**Subject:** Rezoning Petition Review

**Rezoning Petition #:** 22-151

**Location of Property:** Approximately 4.37 acres located along the northeast side of Old Sugar Creek Rd, north of David Cox Rd.

**Recommendations  
Concerning Storm Water:**

DRAWING NUMBER:
RZ-1

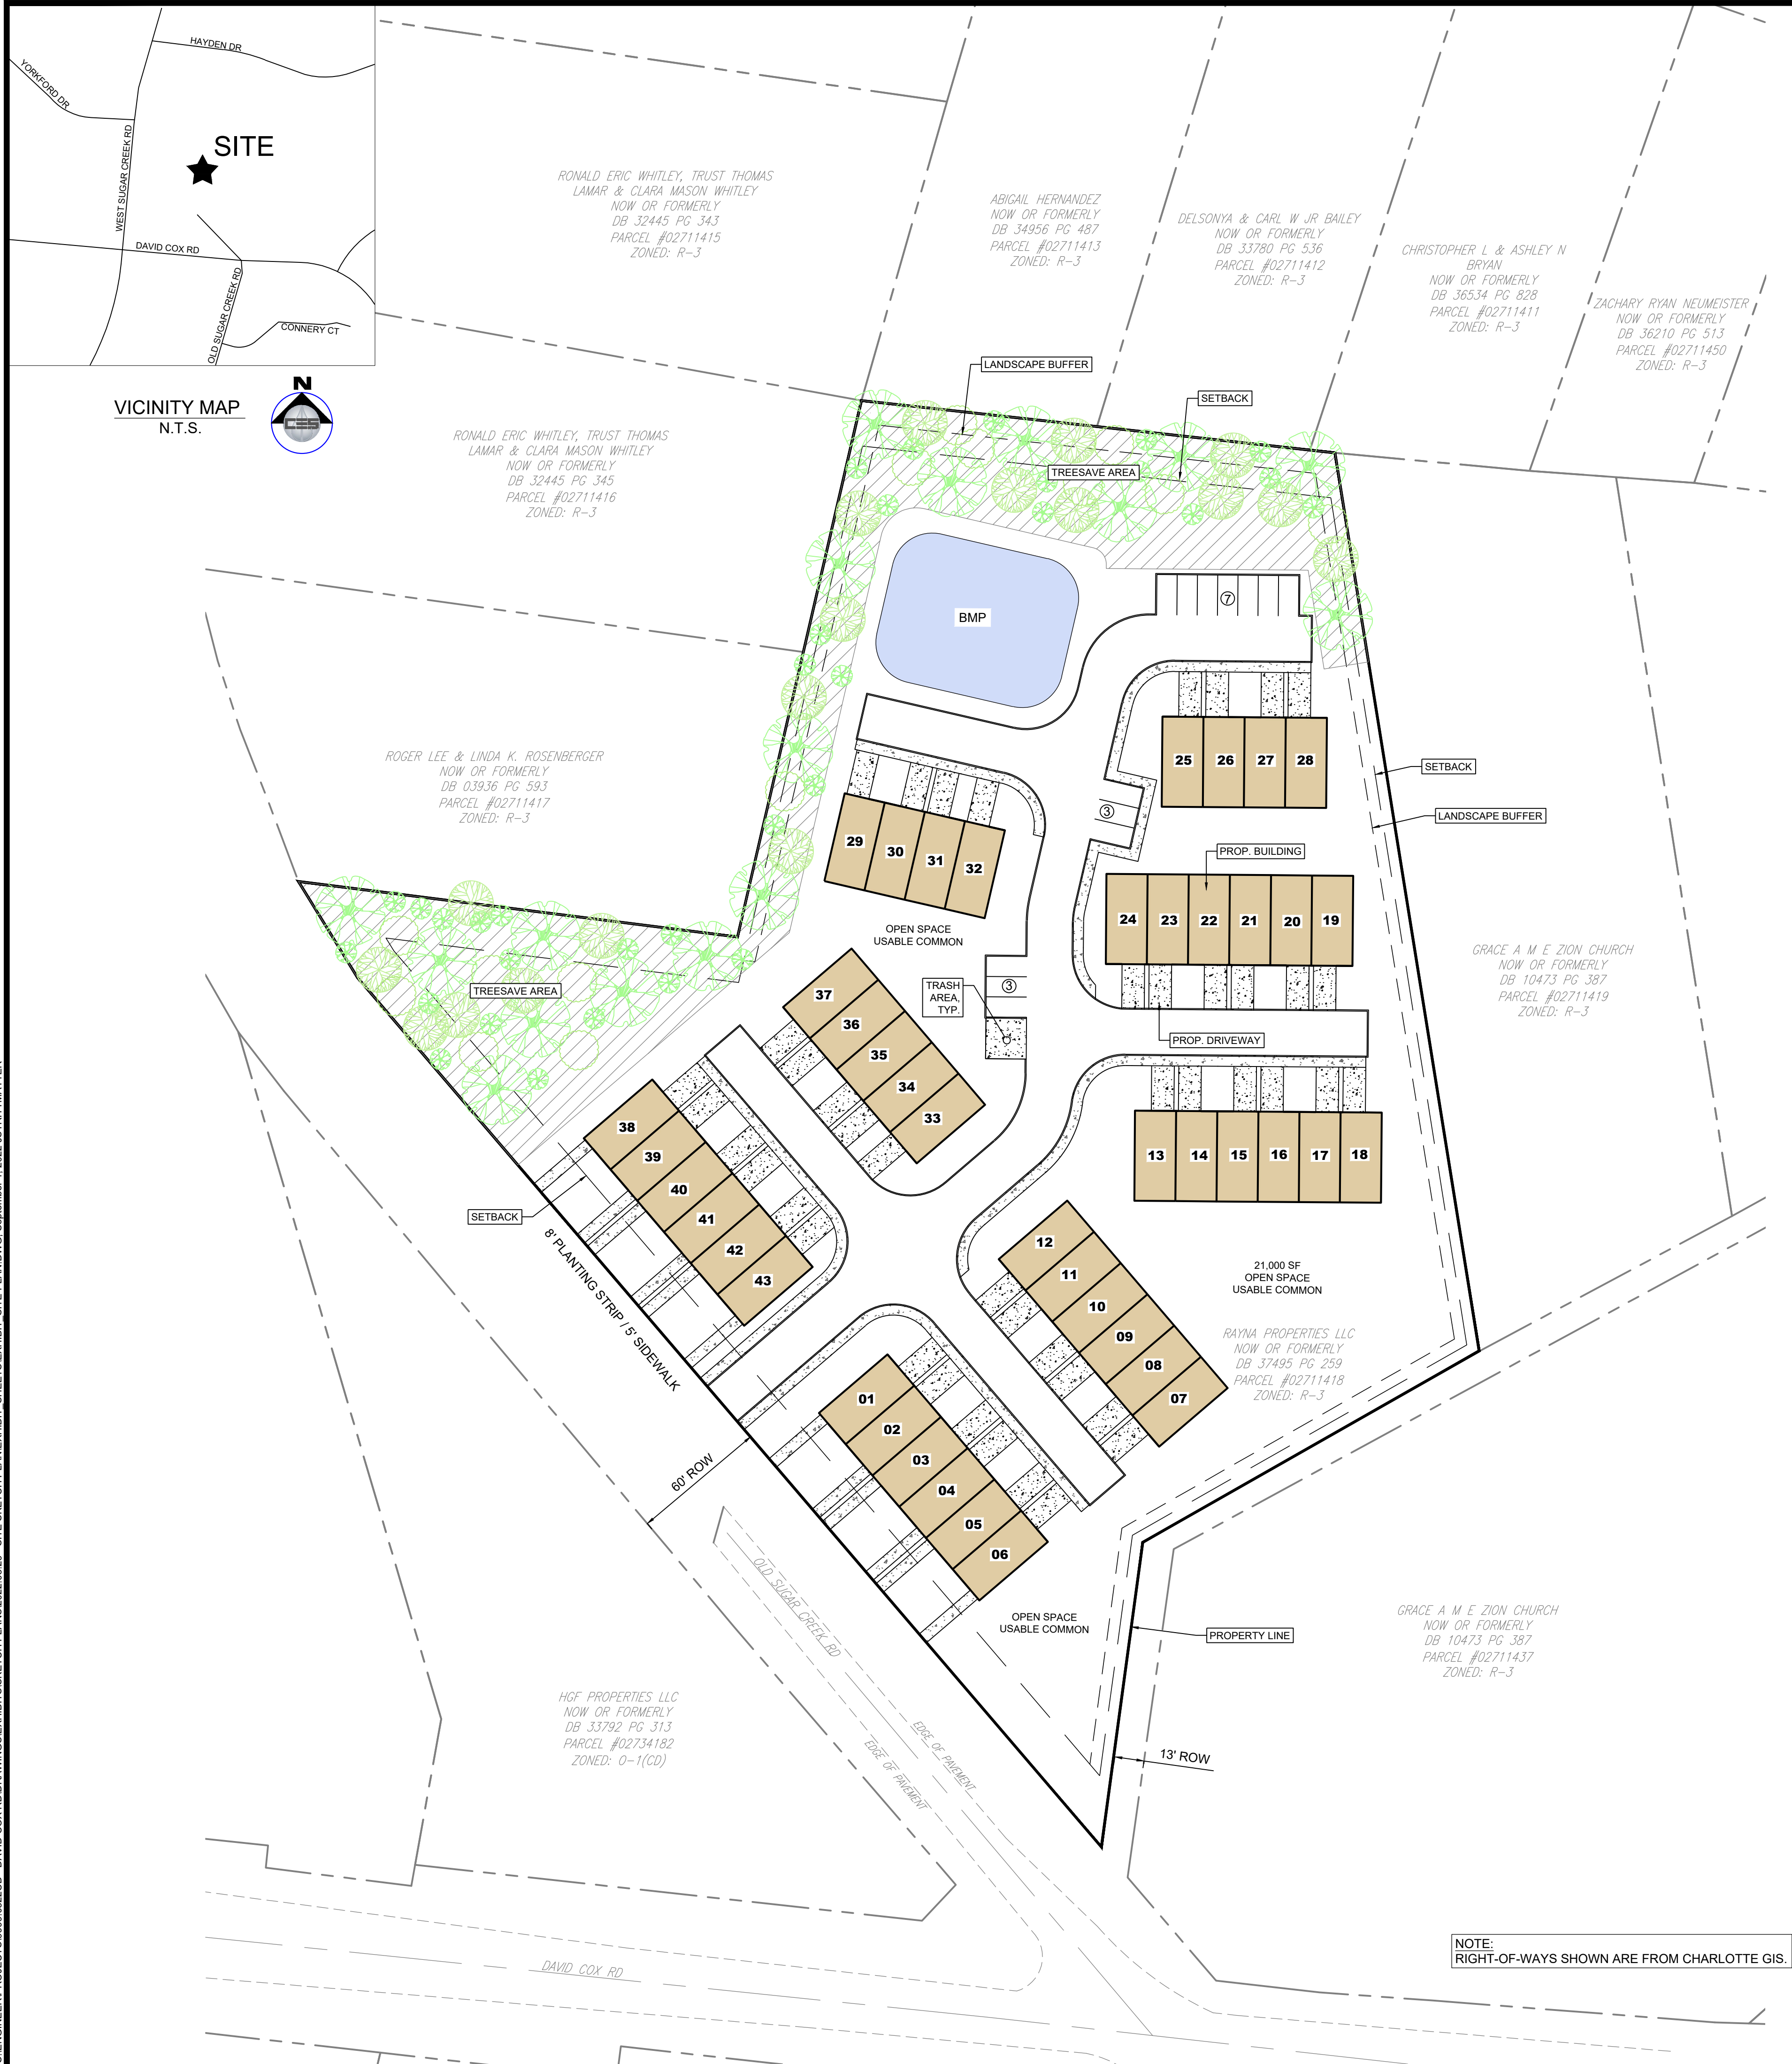
The proposed rezoning plan sheet indicates a proposed location for storm water management. Please include the following notes on the plan sheet under "Environmental Features": The location, size, and type of storm water management systems depicted on the Rezoning Plan are subject to review and approval as part of the full development plan submittal and are not implicitly approved with this rezoning. Adjustments may be necessary in order to accommodate actual storm water treatment requirements and natural site discharge points.

Downstream properties have open Storm Water requests for service. Please include the following note under Environmental Features. For adjoining parcels receiving storm water discharge the petitioner shall analyze the adequacy of the existing storm water conveyance on the adjoining parcels to Hayden Drive. If the existing storm water conveyance on the adjoining parcels is found to be inadequate, the Petitioner shall make a good faith effort with the property owner(s) to improve the storm water conveyance or mitigate the storm water discharge onto the adjoining parcels.
